## LBH-PM-191105

### LBH RESIDENCE PROJECT MEMO

*Project:* 7450 N Mercer Way  
Mercer Island, Washington 98040

**RE: PERMIT NUMBER: 1904-048  
POST-PERMIT REVISIONS APPLICATION**

A-2.2

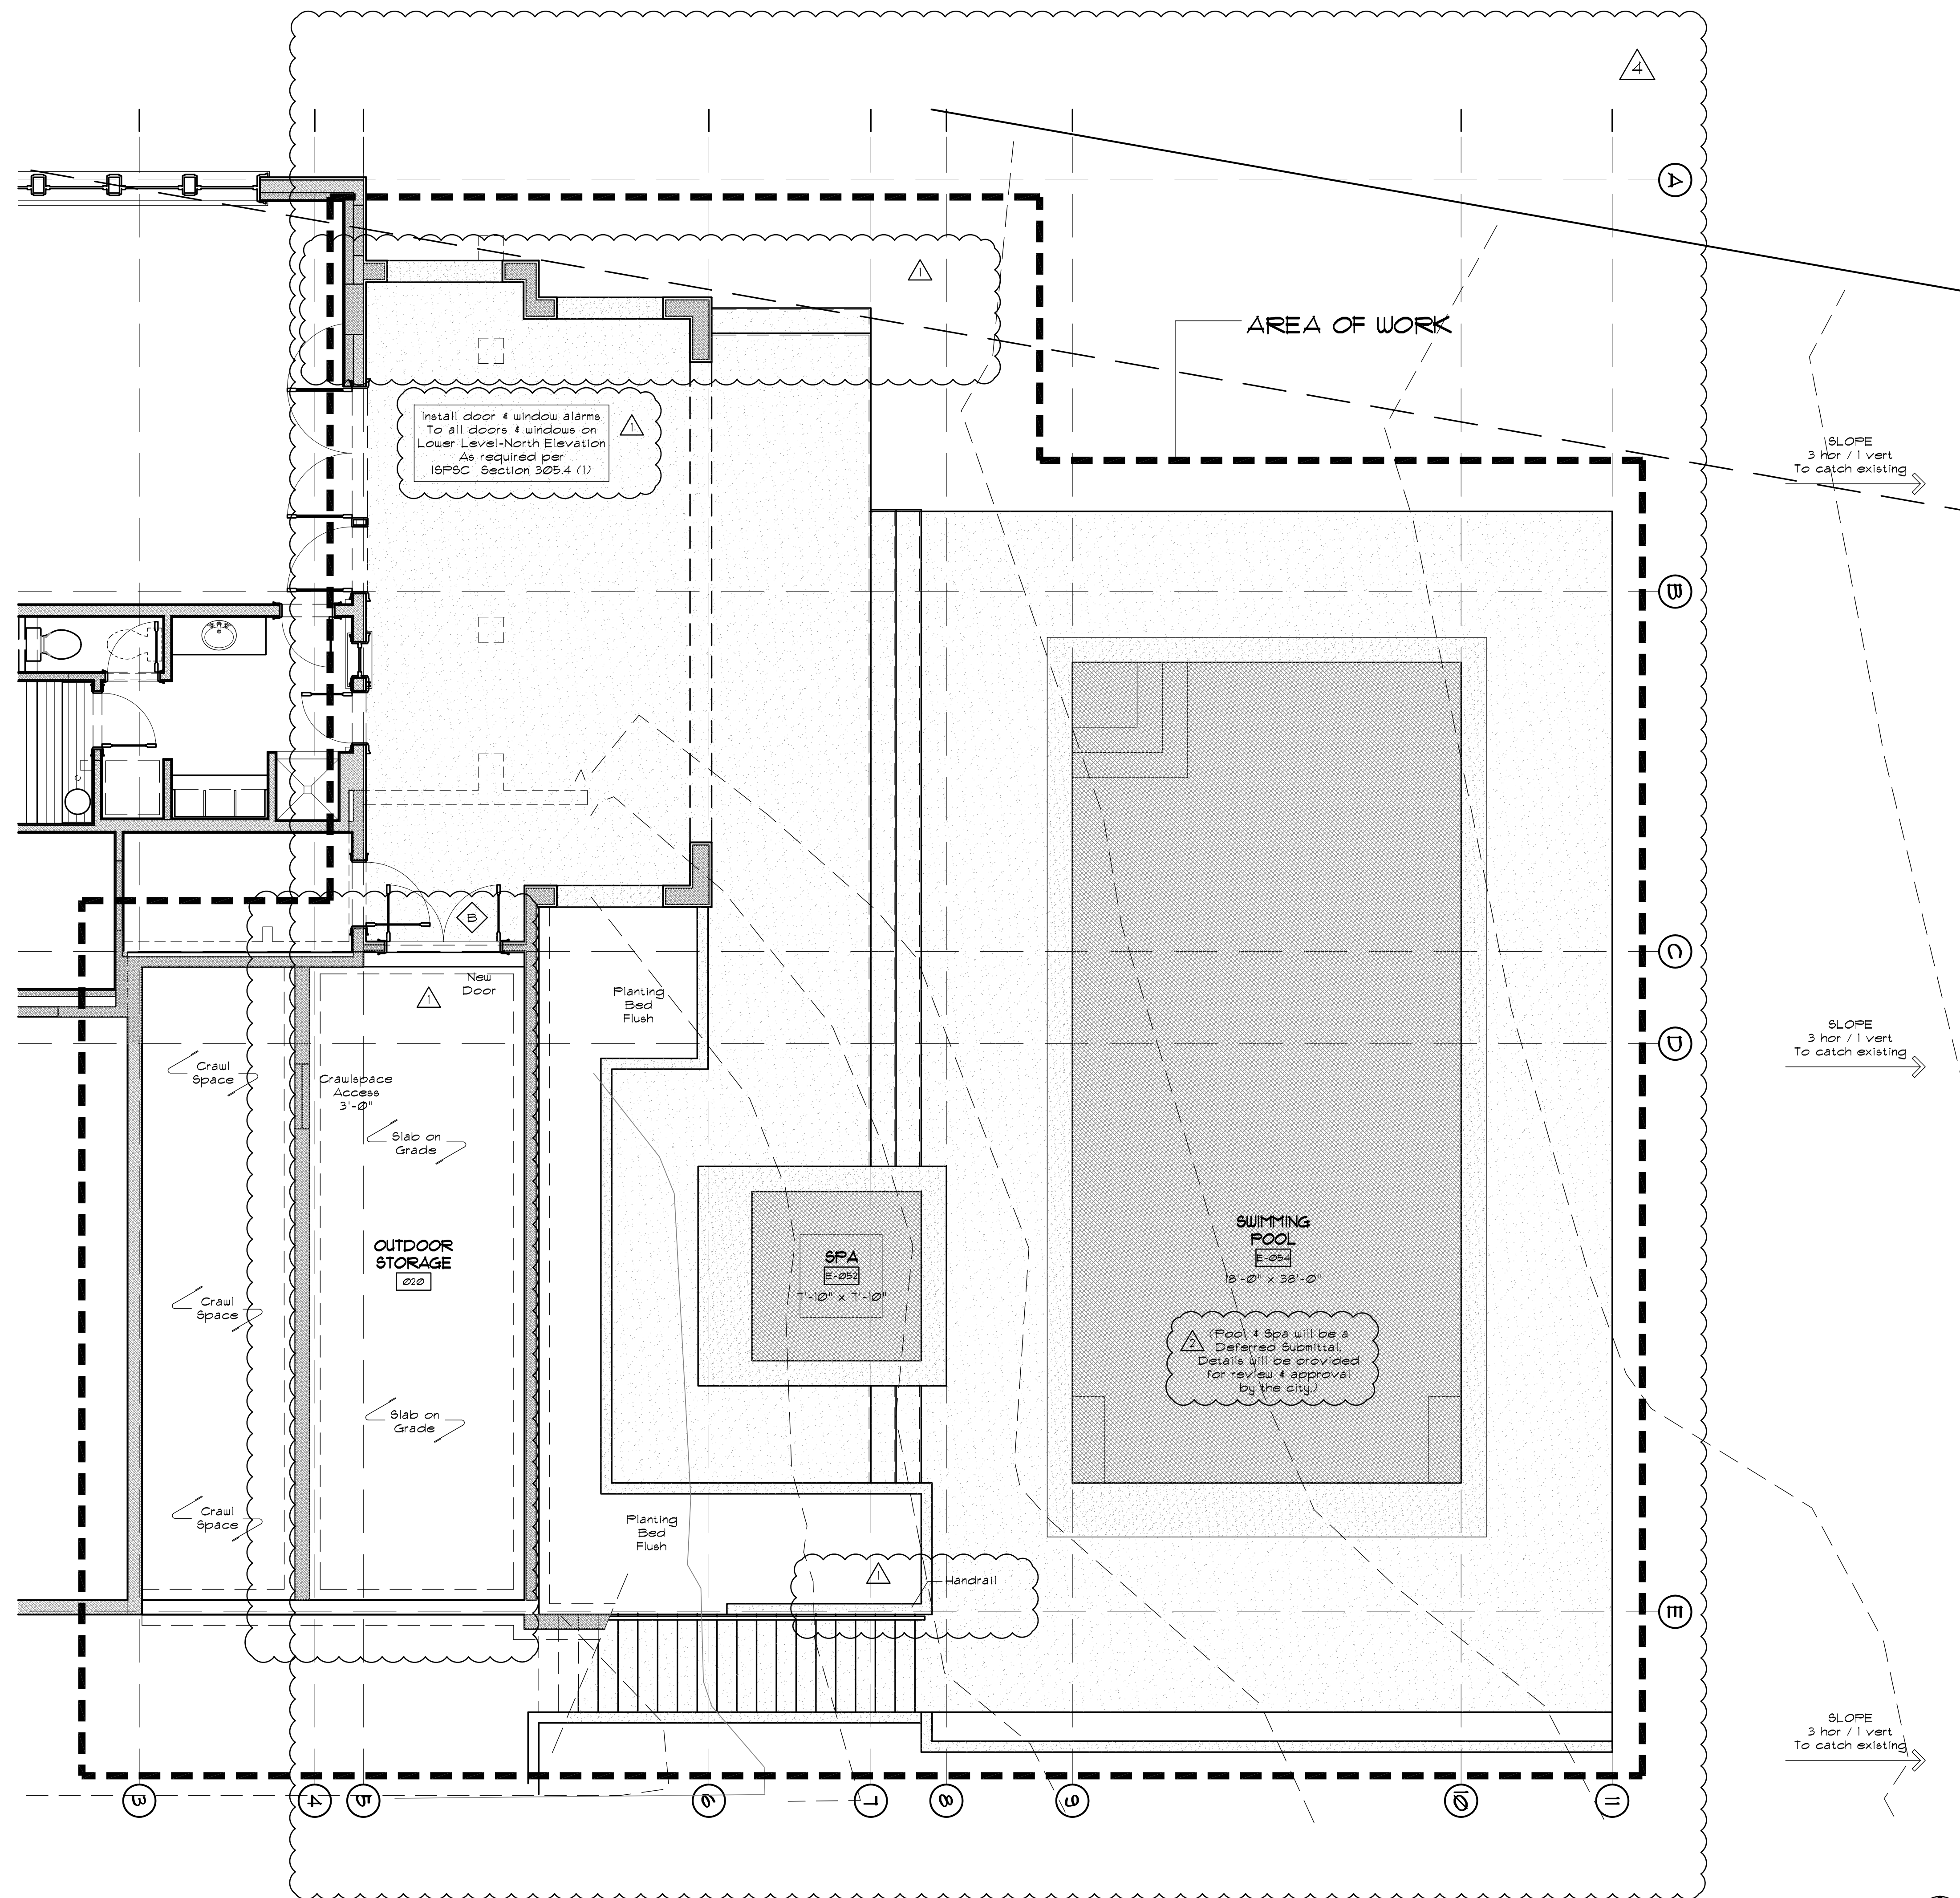
Main Covered Porch has been revised. Pool Stair landing and stair have been revised.

B SYMBOL B LOCATION Outdoor Storage DOOR DIAGRAM Scale: 1/2" = 1'-0"

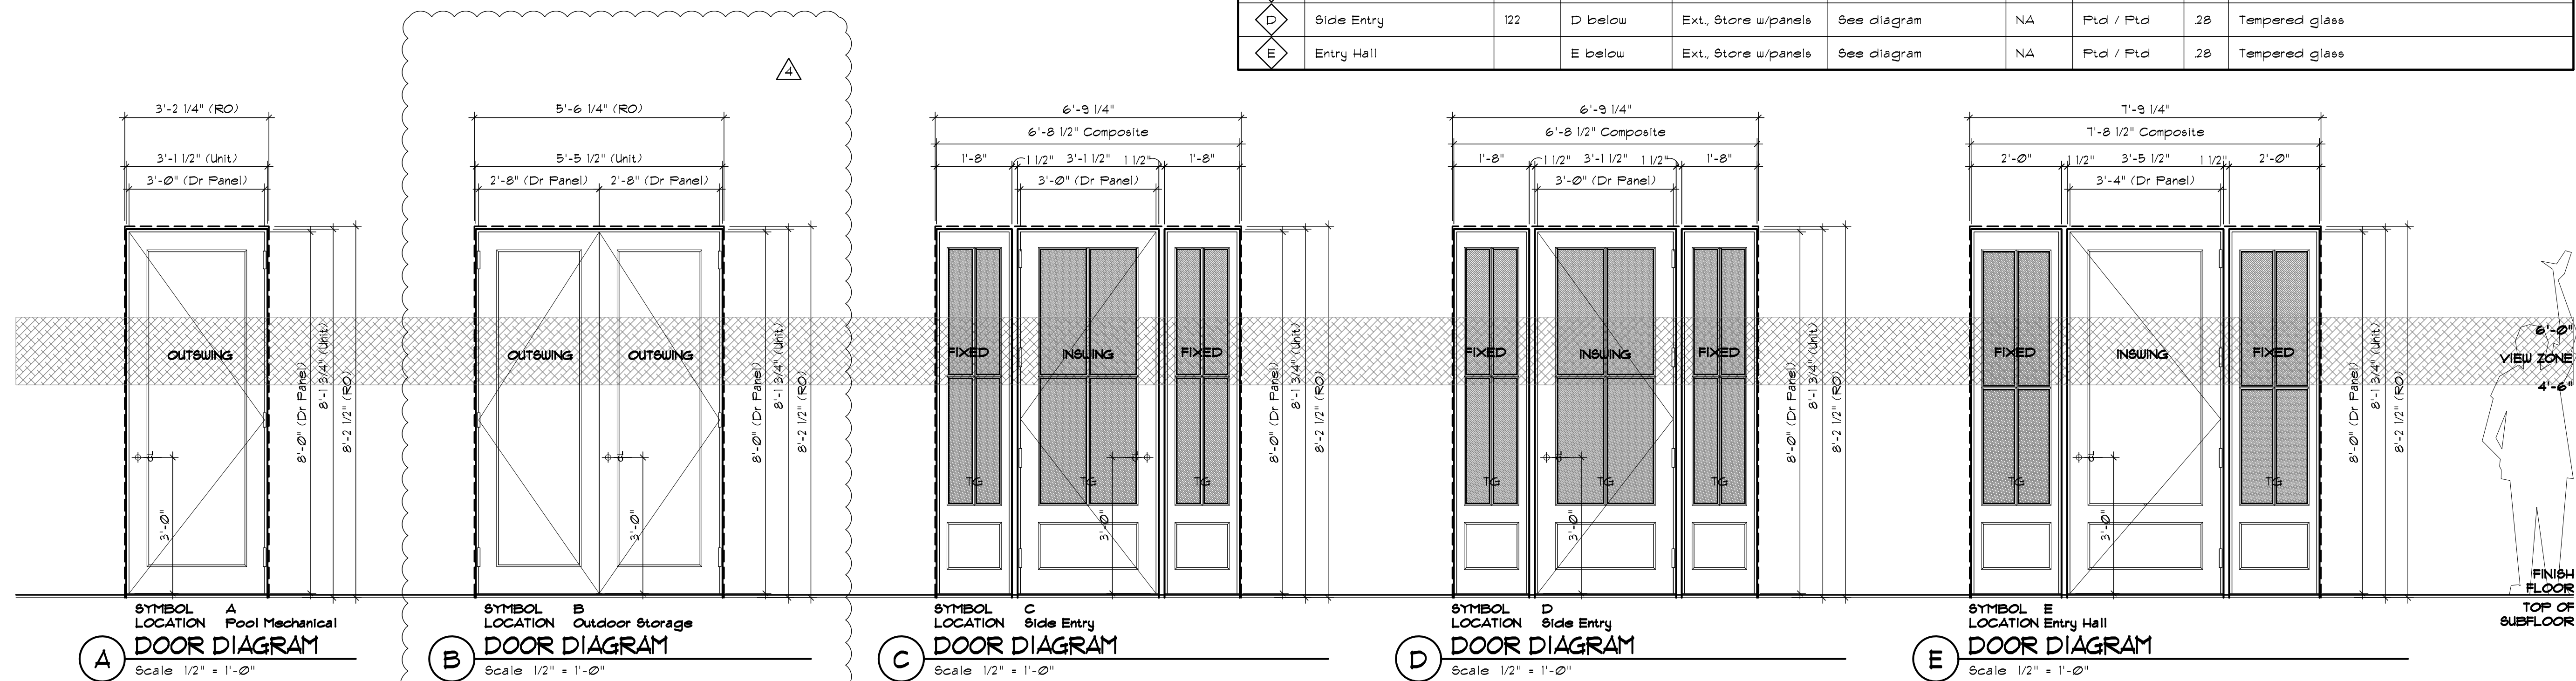
Door B has been revised from a single door to a pair of doors.
